## *City of Albuquerque*

February 12, 1985

RE: DRAINAGE PLAN FOR SPECIAL SYSTEMS, INC. WAREHOUSE (J-14/D48)  
RECEIVED JANUARY 29, 1985

**DRAINAGE / GRADING PLAN**  
**SPECIAL SYSTEMS INC. WAREHOUSE**  
**1301 EDITH BLVD. N.E.**

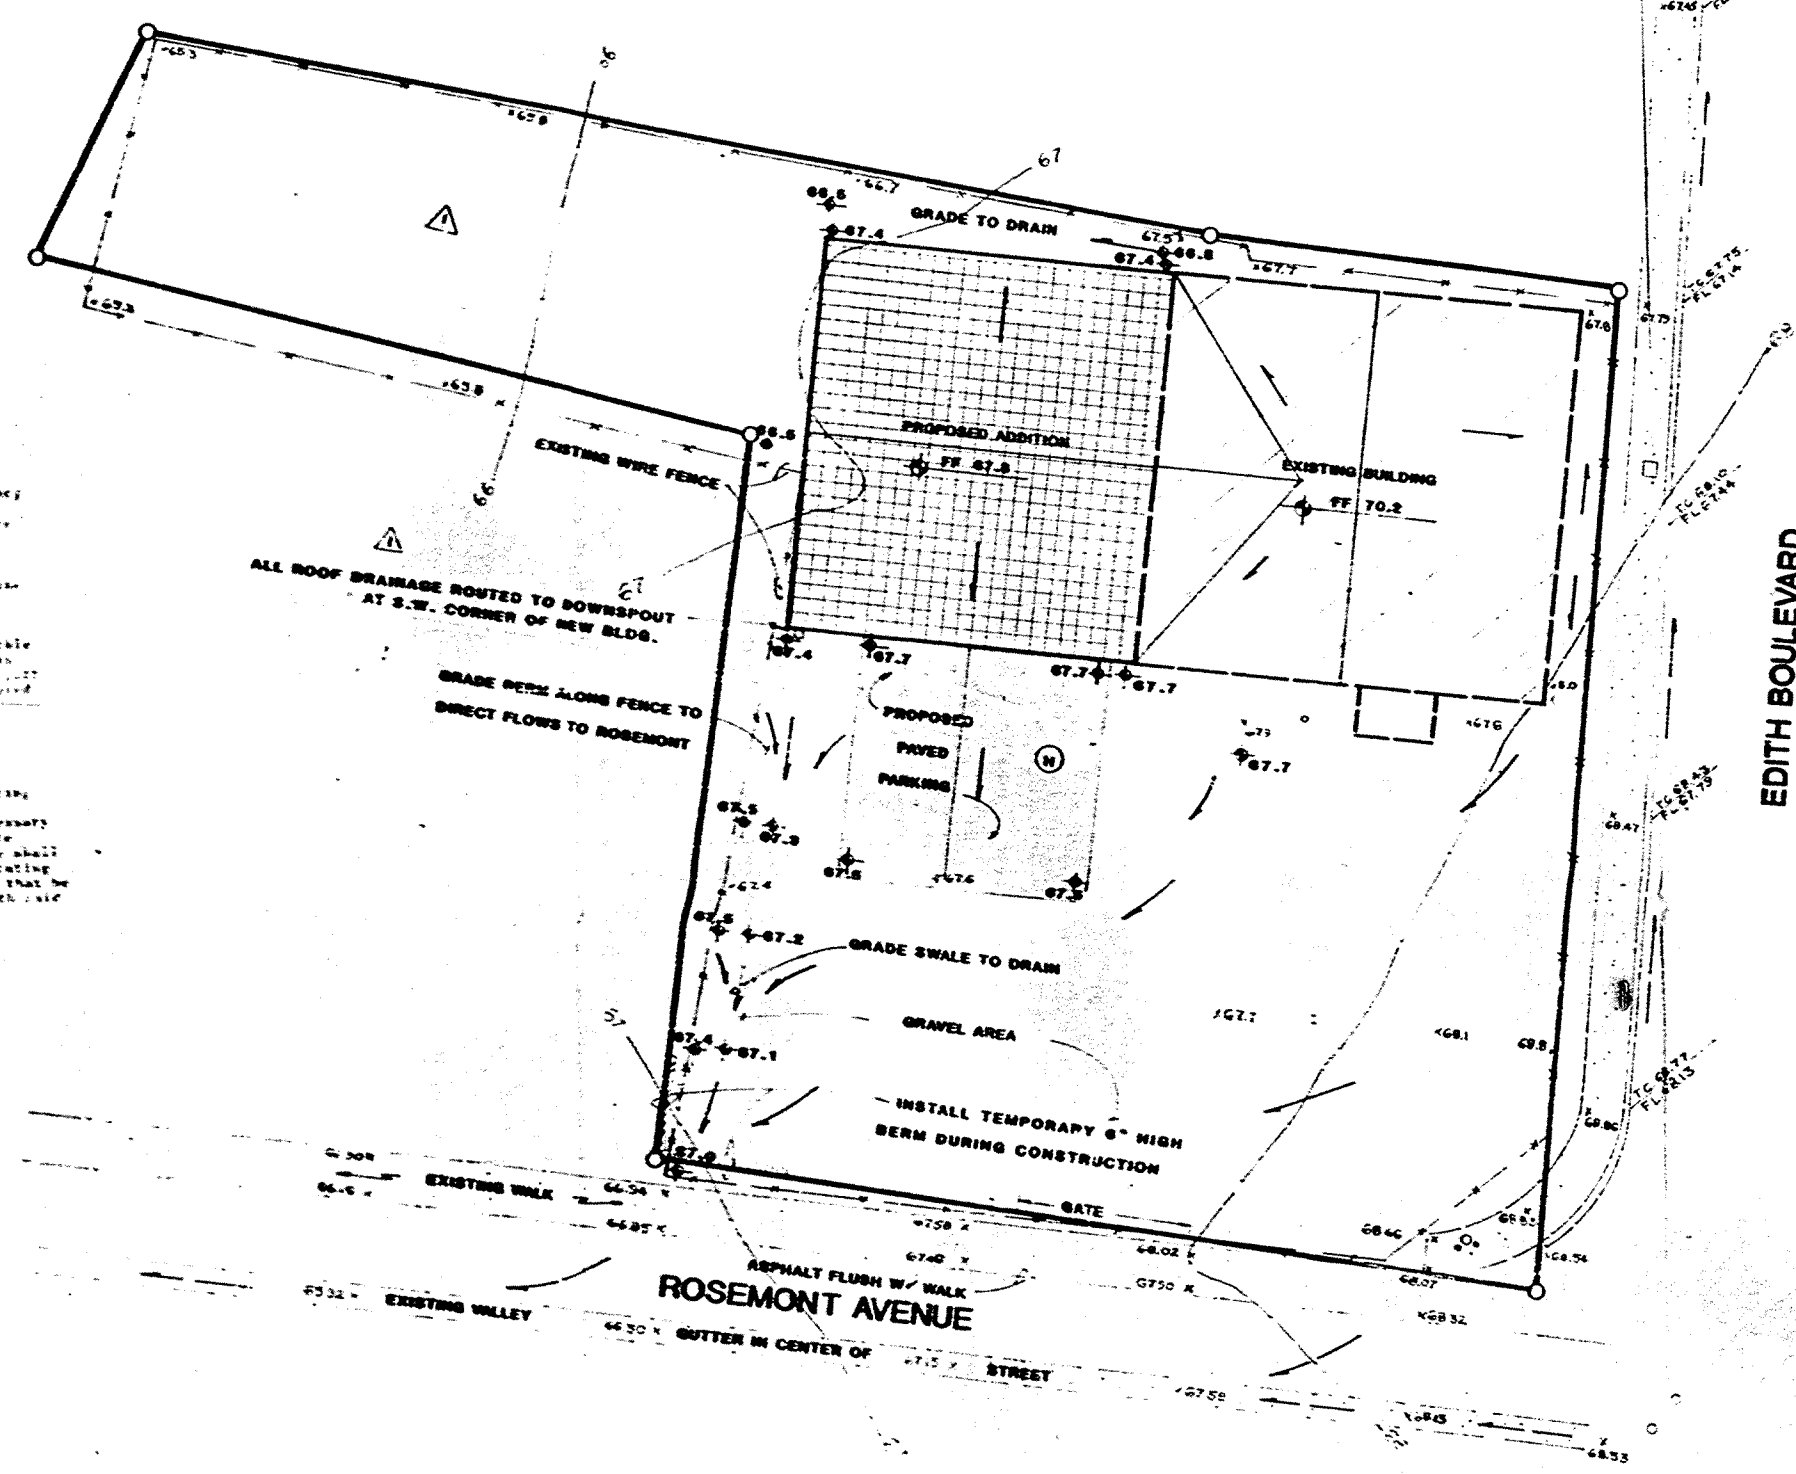
Based on City Ordinance, all ponds must drain within 24 hours. Please indicate the type of outlet that will be used on NW pond. Please submit a plat showing the removal of lot lines or a drainage covenant that allows flow across lot lines.
